**ADC Planning Consultation
Response from the Conservation Officer**

Application Number	A/129/15/PL
Address	Blaber House The Square Angmering BN16 4EF
Description	Replacement of glass roof to existing covered courtyard, removal of valley to rear, removal of chimney stack to rear, insertion of first floor window to rear, re-roofing of main roof & repair of existing boundary wall
Case Officer	Mrs. A Gardner

Drawing Title
Plans and Elevations
as Proposed

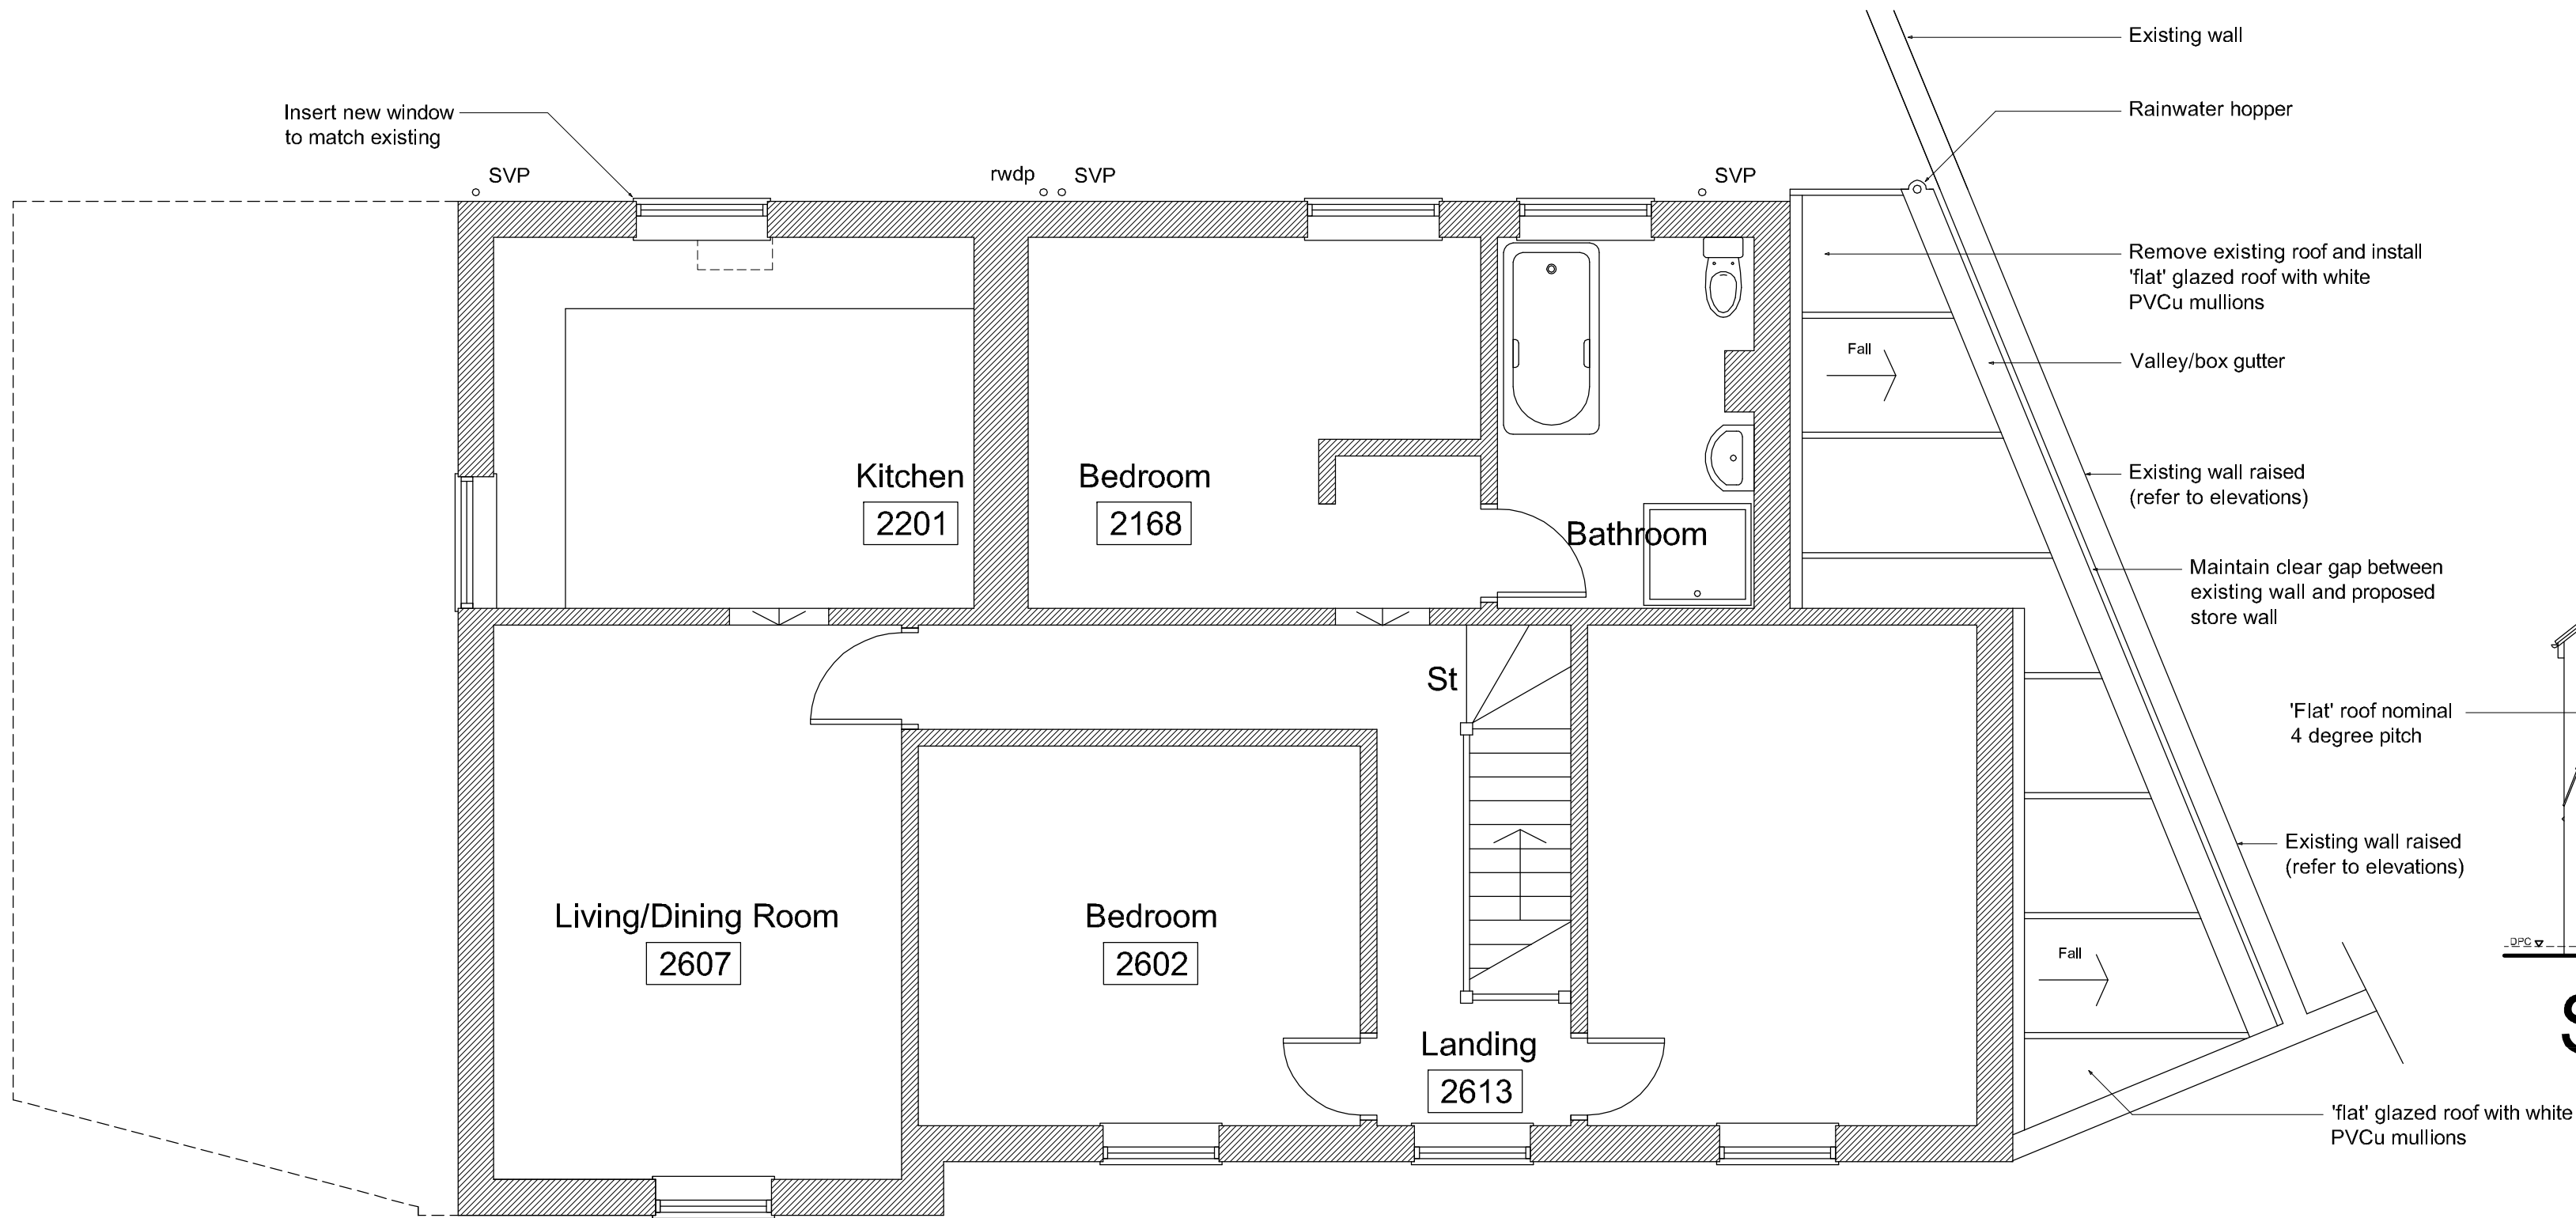
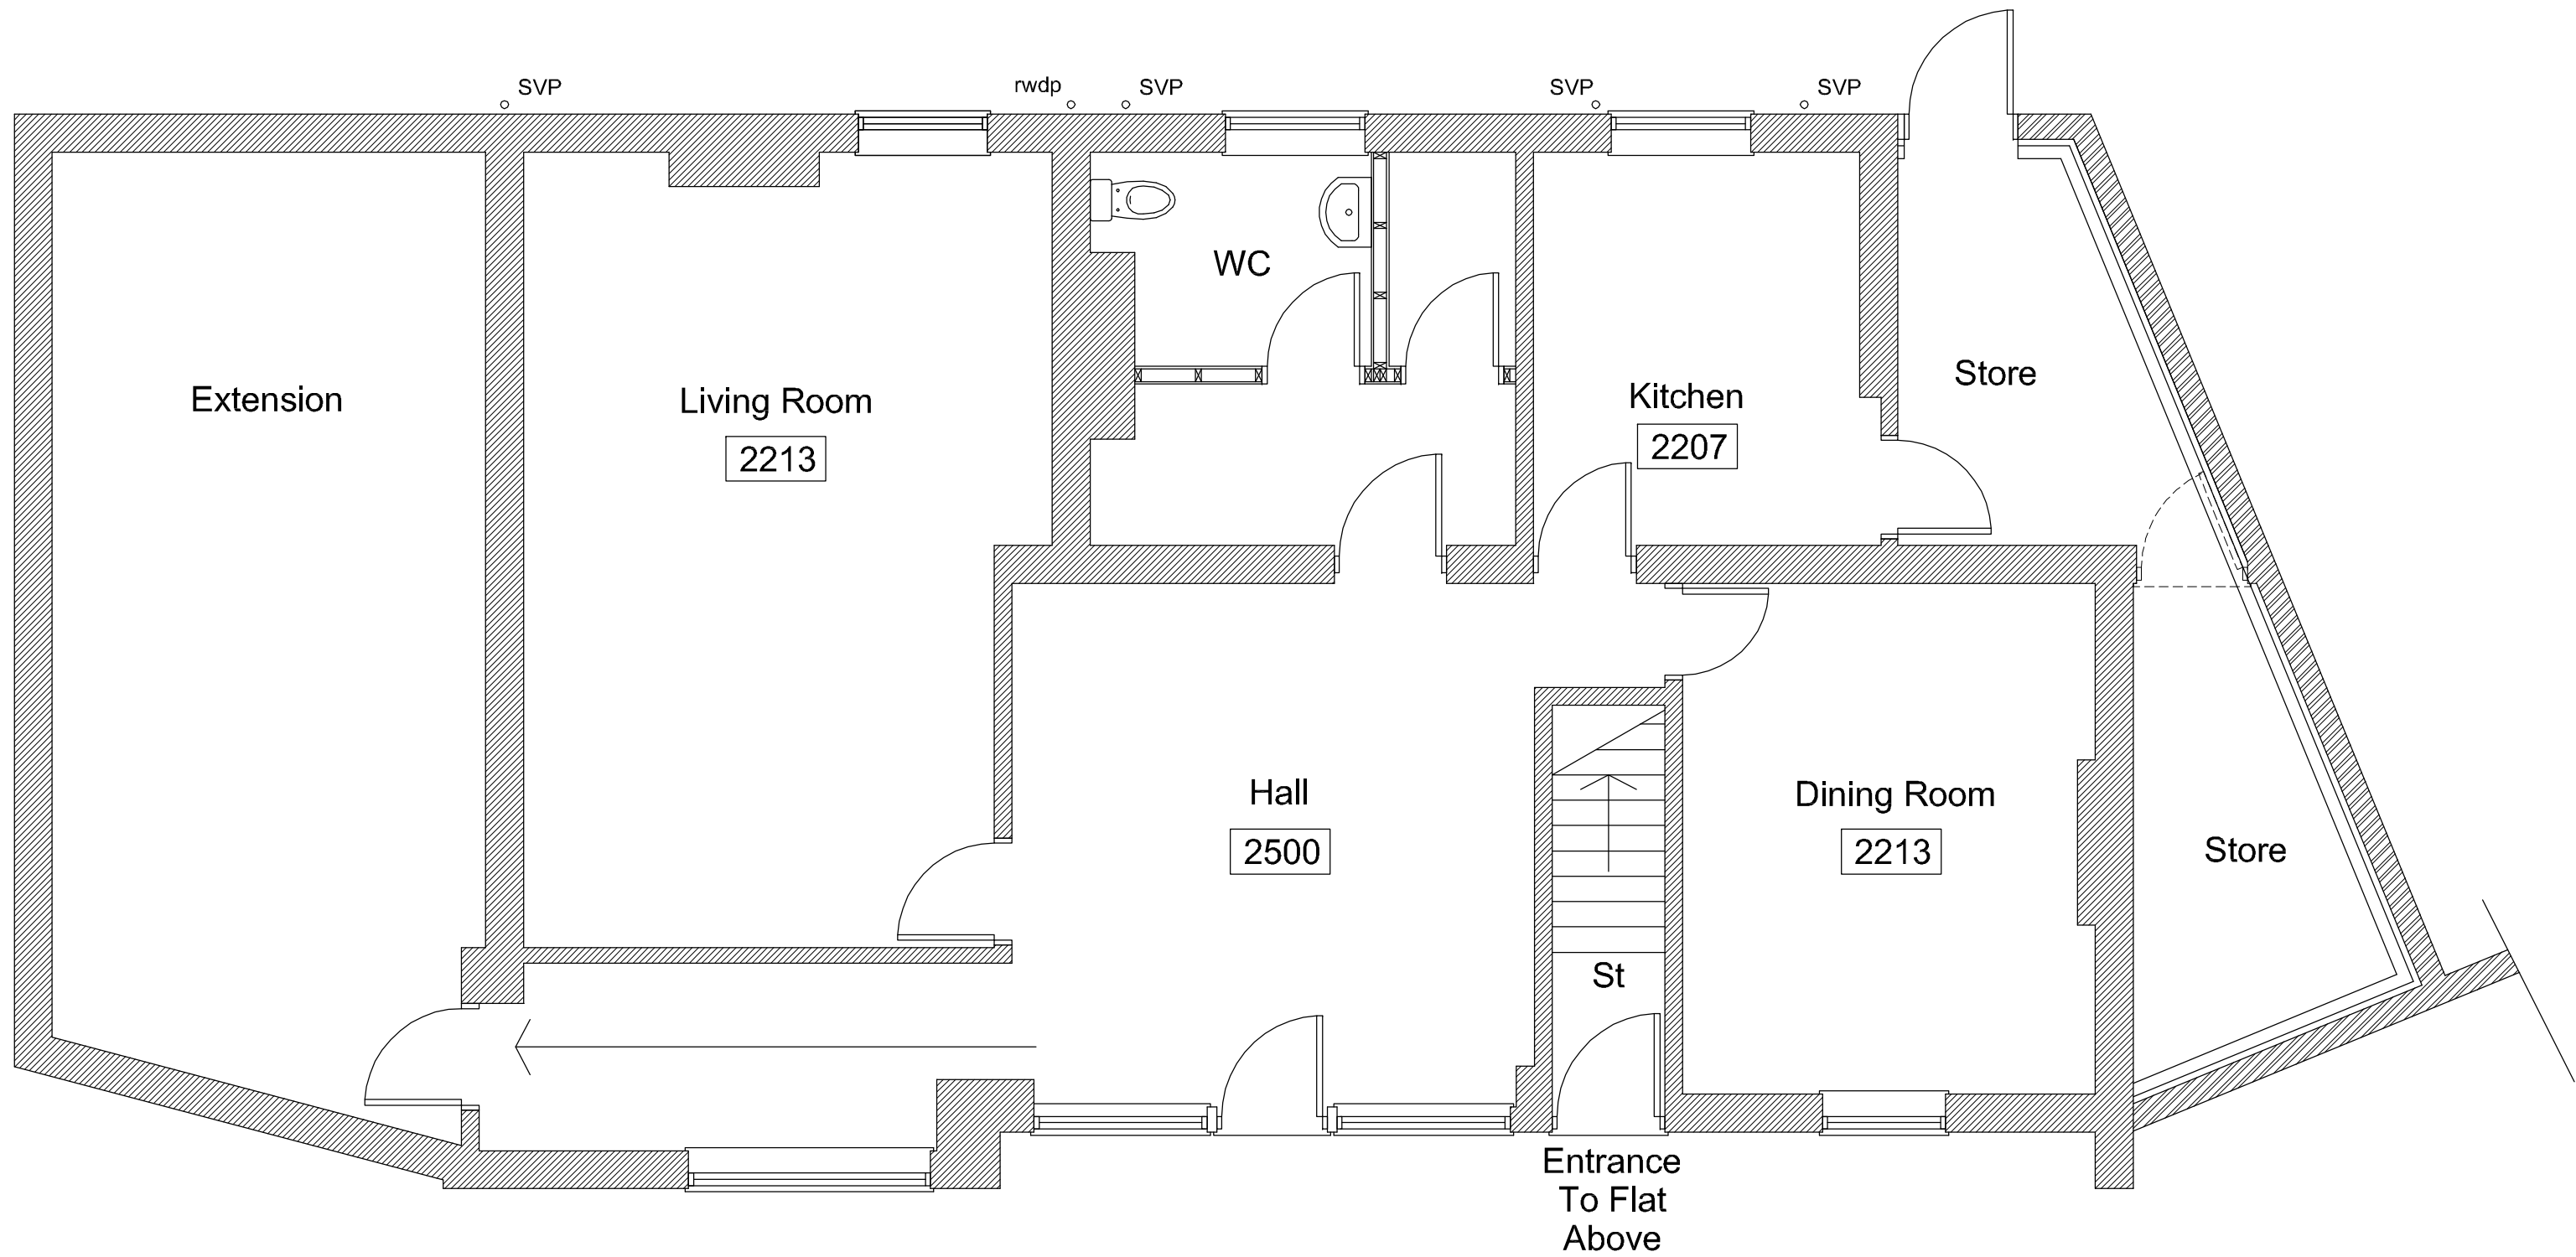
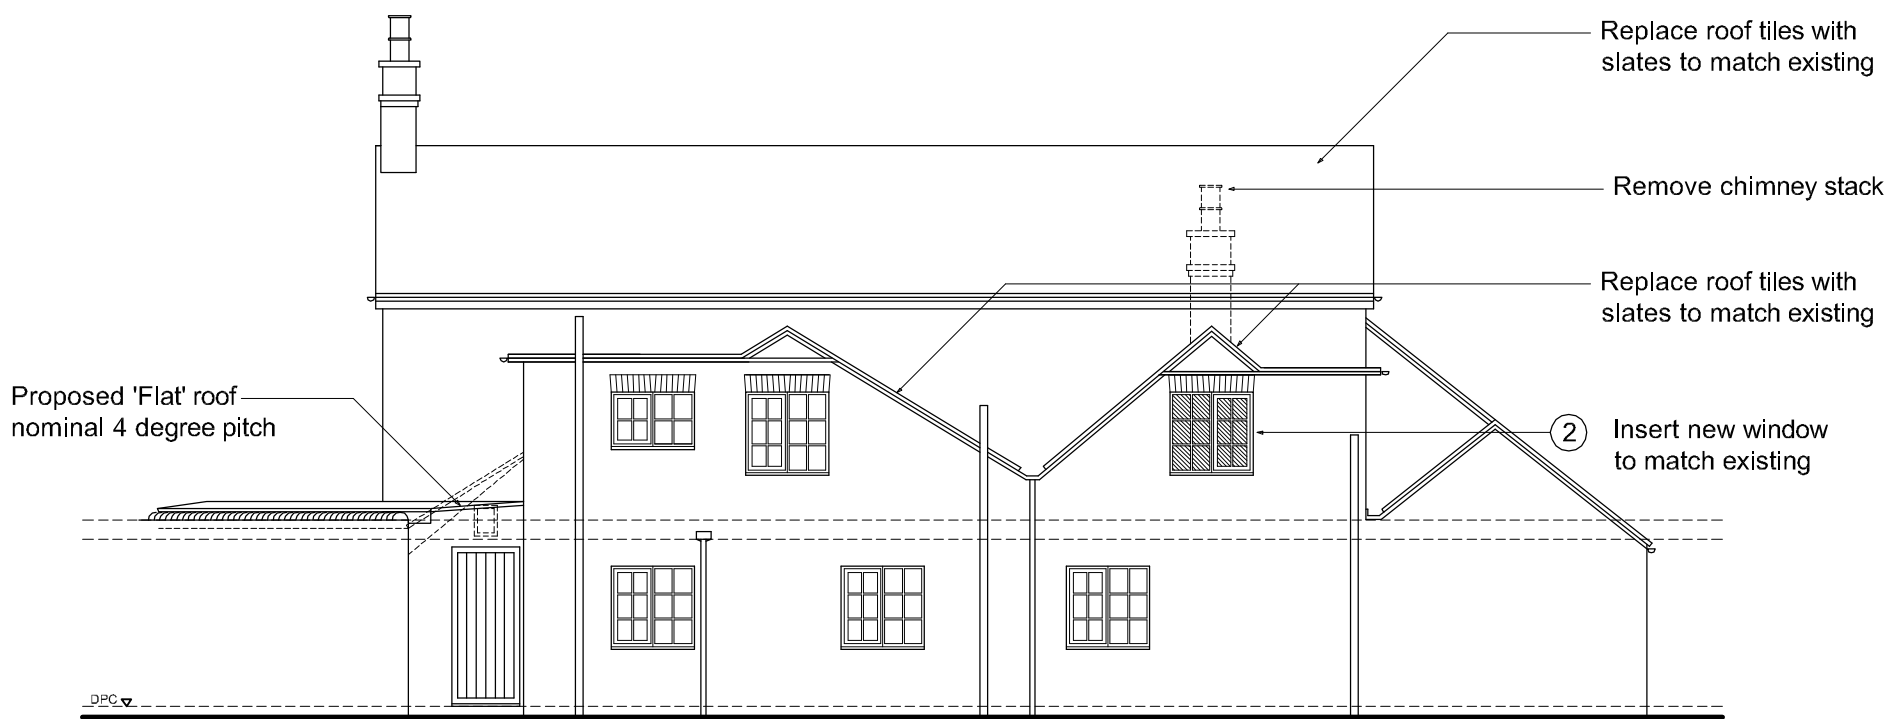
These comments relate to amended plans. It is noted that the works to the roof have been removed from the proposal, and this is supported.

The revised proposals are now considered to have a neutral impact upon the property or local area.

Details of all materials will need to be provided along with details of how the existing boundary wall is to be repaired. This may also require a sample panel to be provided on site.
